EL PASO COUNTY PLANNING AND COMMUNITY DEVELOPMENT DEPARTMENT

GRADING AND EROSION CONTROL PLAN CHECKLIST

COVER SHEET

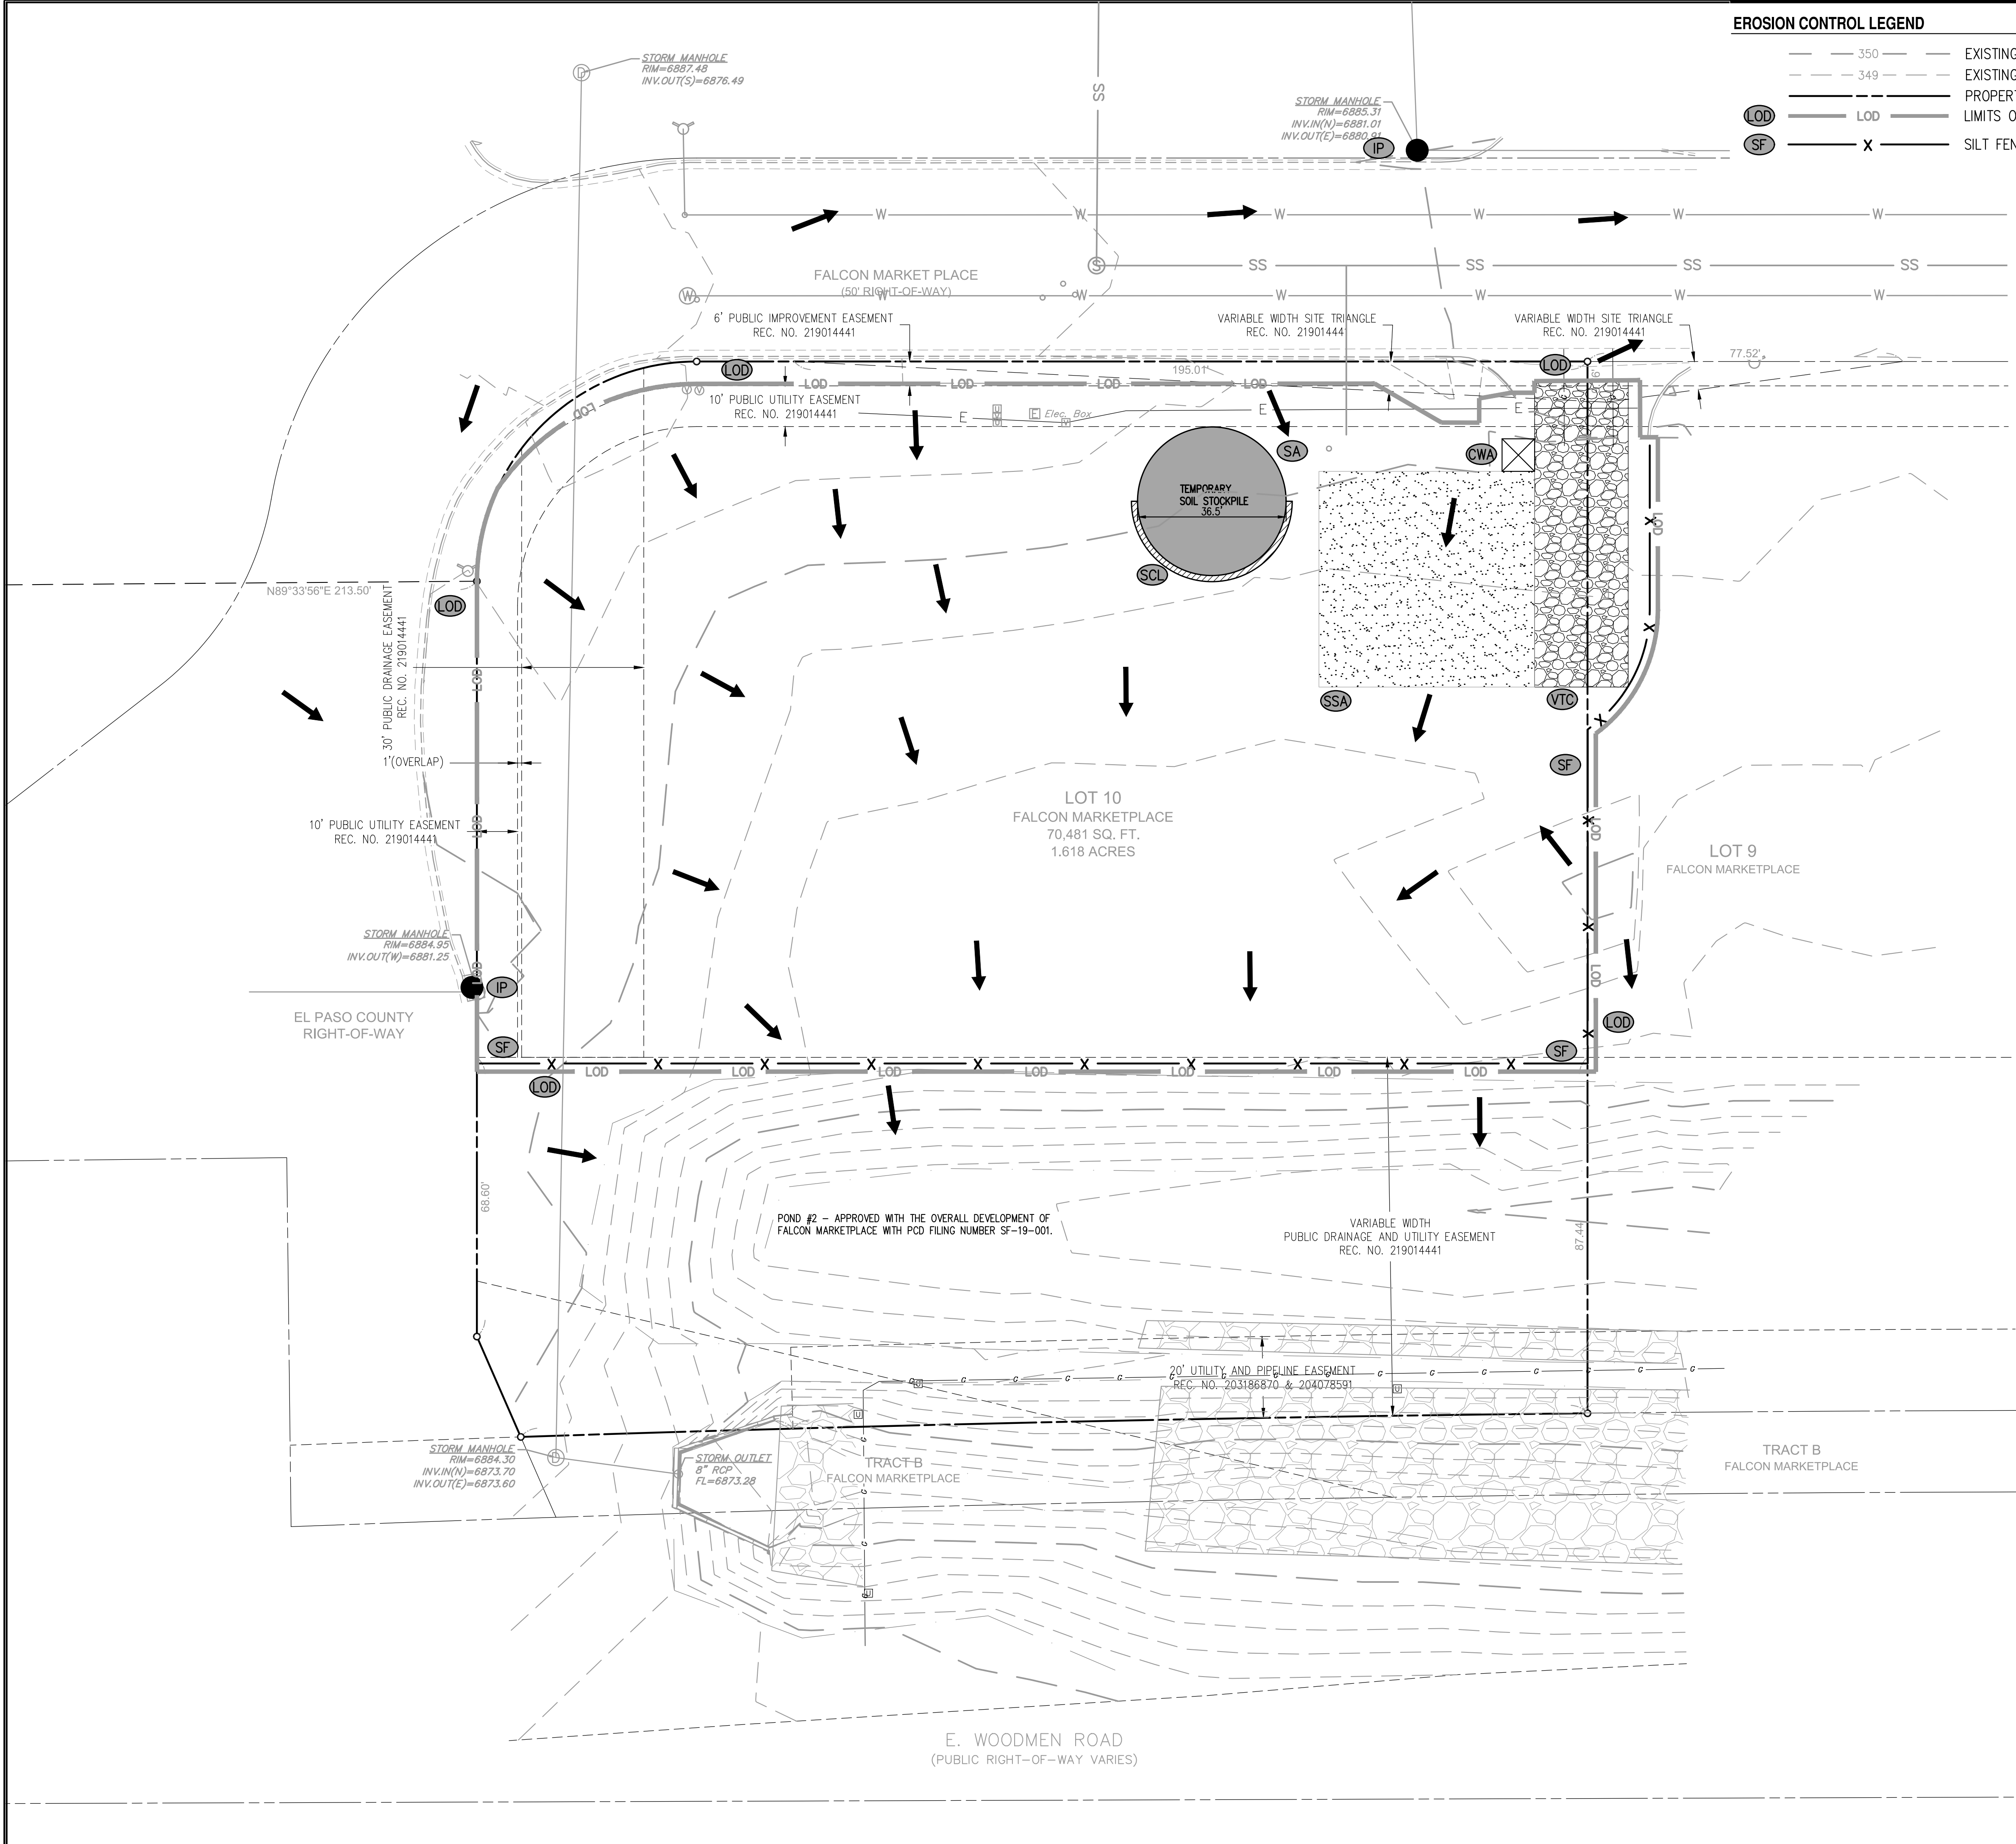
This is incorrect. Our revised Checklist has removed it. This signature block should be included on the title page of CD's.

DESIGN	DRAWN	CHKD
SWK	SWK	TOP
SCALE	H: 1" = 20' V: 1" = XXX'	
JOB No.	020441-01-001	
DATE :	02/09/2021	
SHEET	C2.0

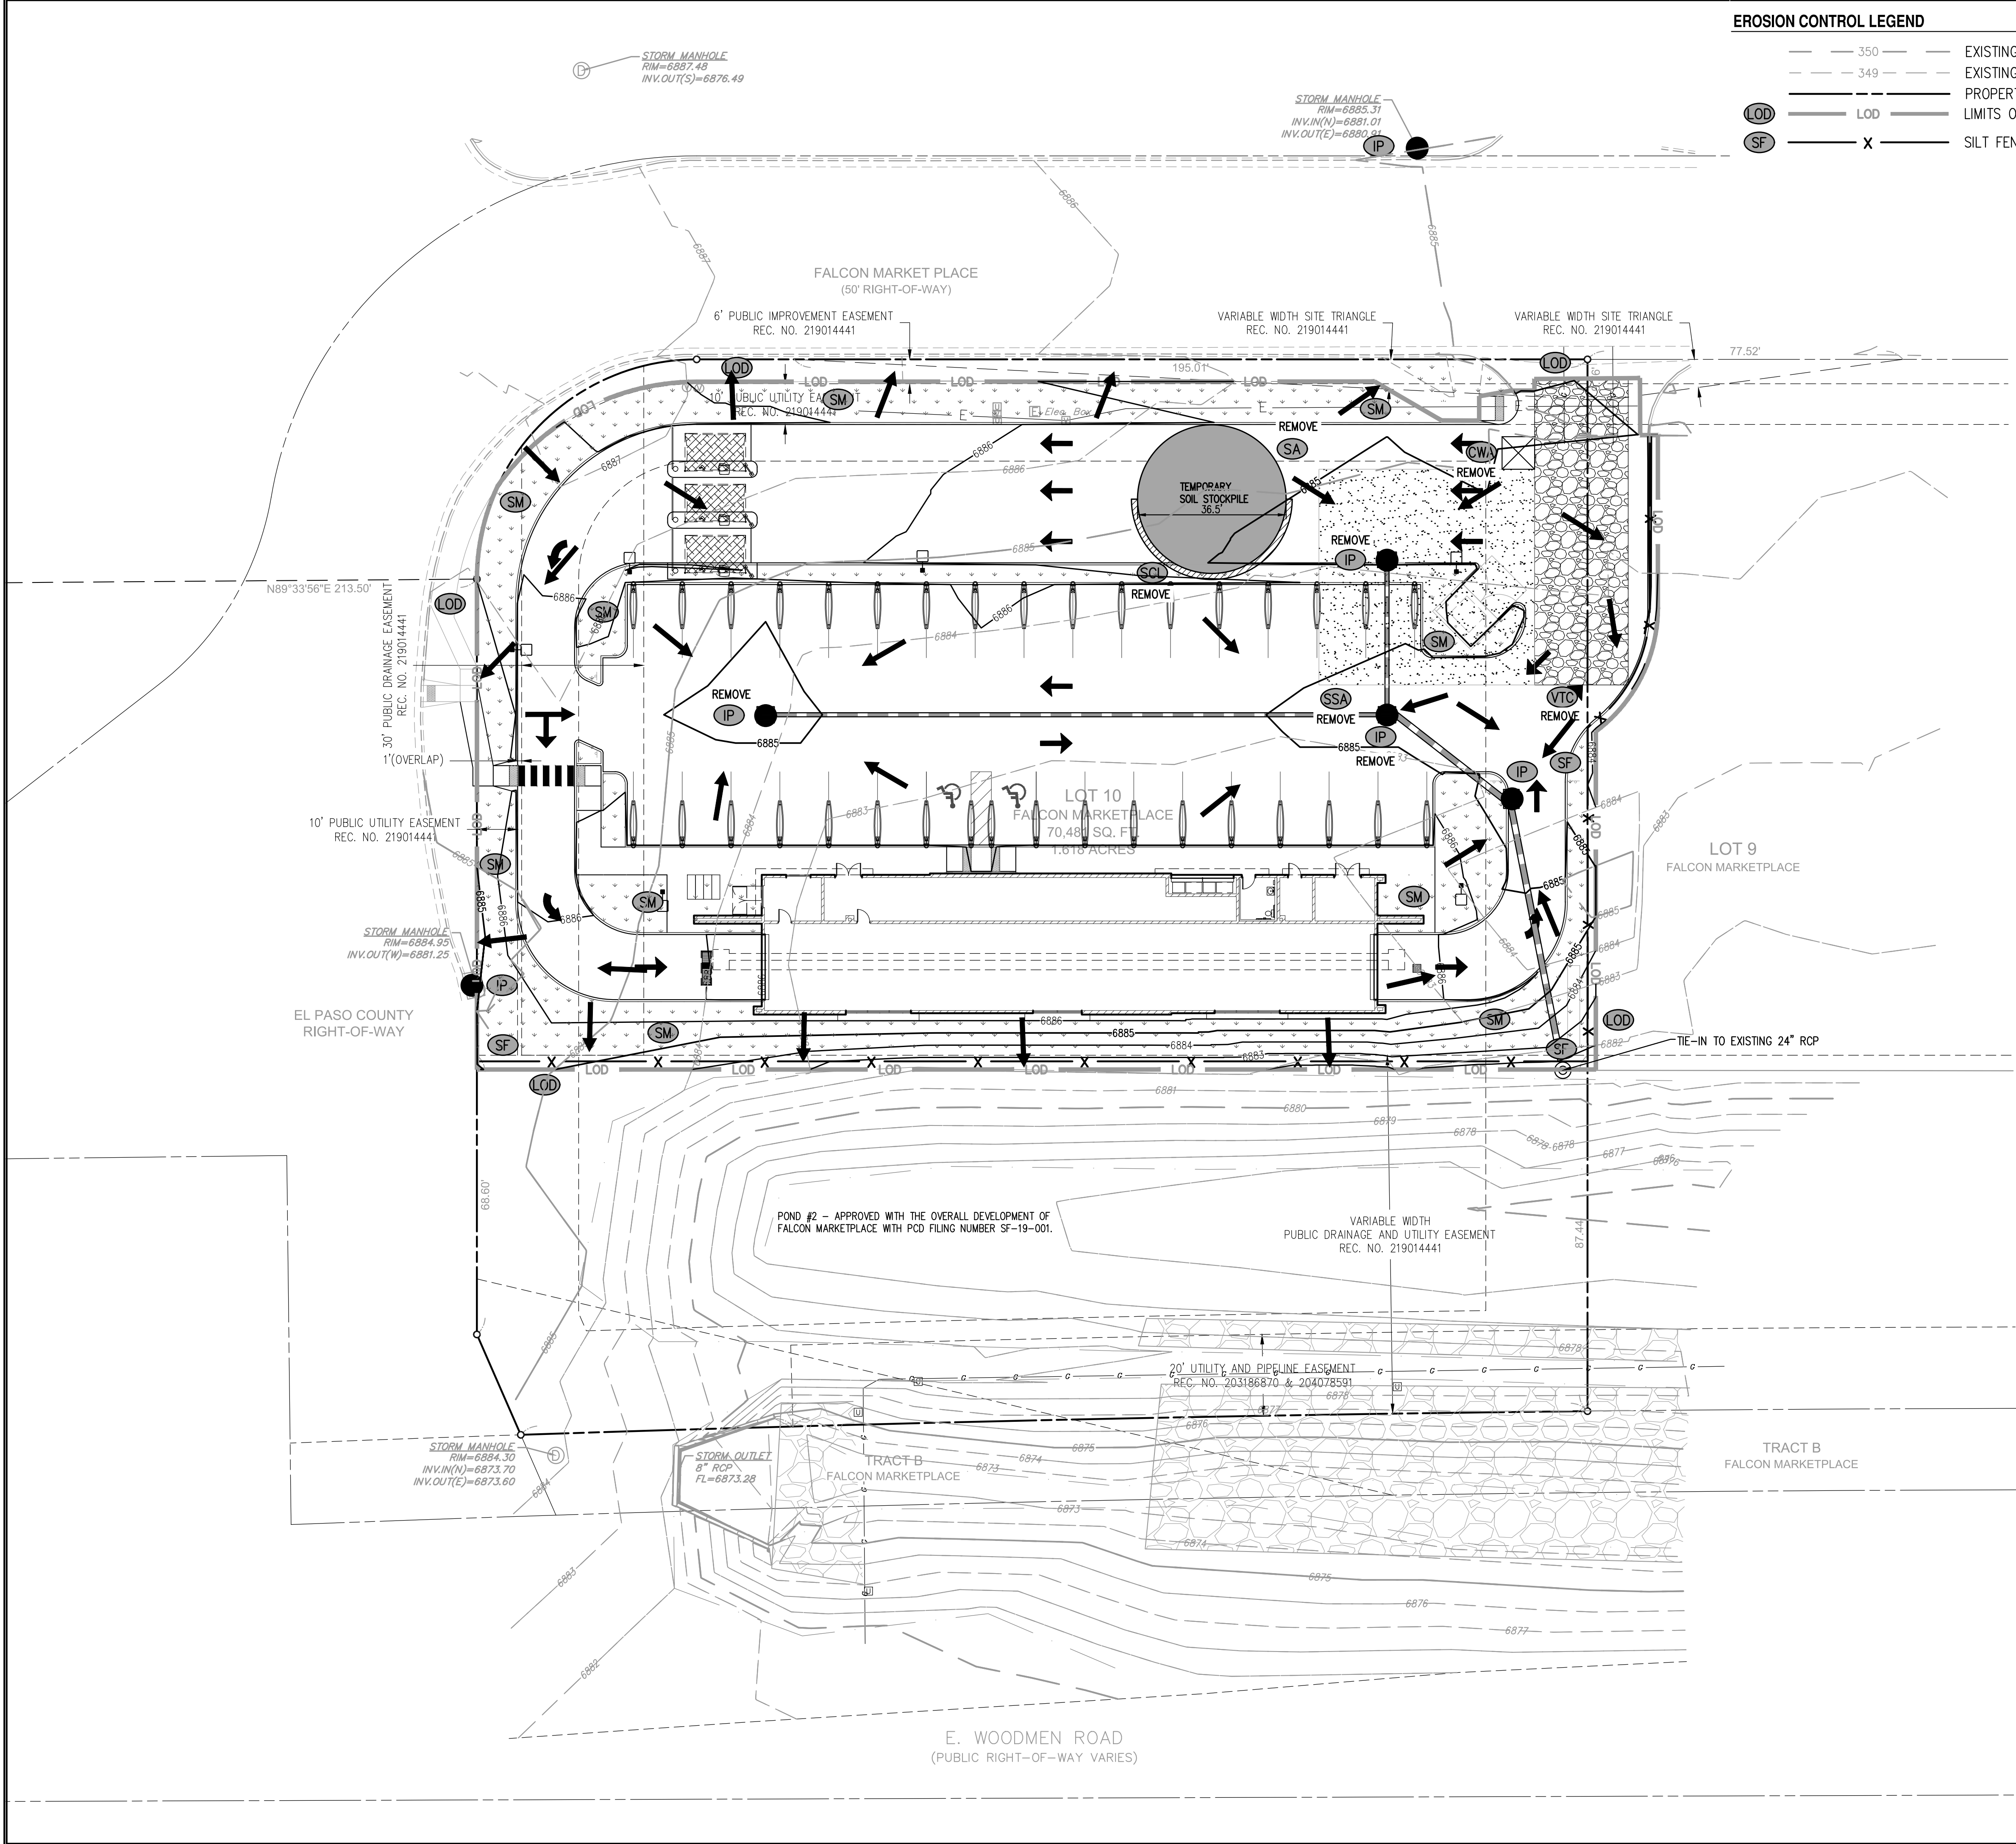
l	Existing and proposed contours 2 feet or less (except for hillside).		Y
m	Limits of disturbance delineating all anticipated areas of soil disturbance.		N
n	Identify and protect areas outside of the construction site boundary with existing fencing, construction fencing or other methods as appropriate.	none	N/A
o	Offsite grading clearly shown and called out.	No offsite grading	N/A
p	Areas of cut and fill identified.		Y
q	Conclusions from soils/geotechnical report and geologic hazards report incorporated in grading design (slopes, embankments, materials, mitigation, etc.)		Y
r	Proposed slopes steeper than 3:1 with top and toe of slope delineated. Erosion control blanketing or other protective covering required.		N/A
s	Stormwater flow direction arrows.		Y
t	Location of any dedicated asphalt / concrete batch plants.		N/A
u	Areas used for staging, storage of building materials, soils (stockpiles) or wastes. The use of construction office trailers requires PCD permitting.		Y
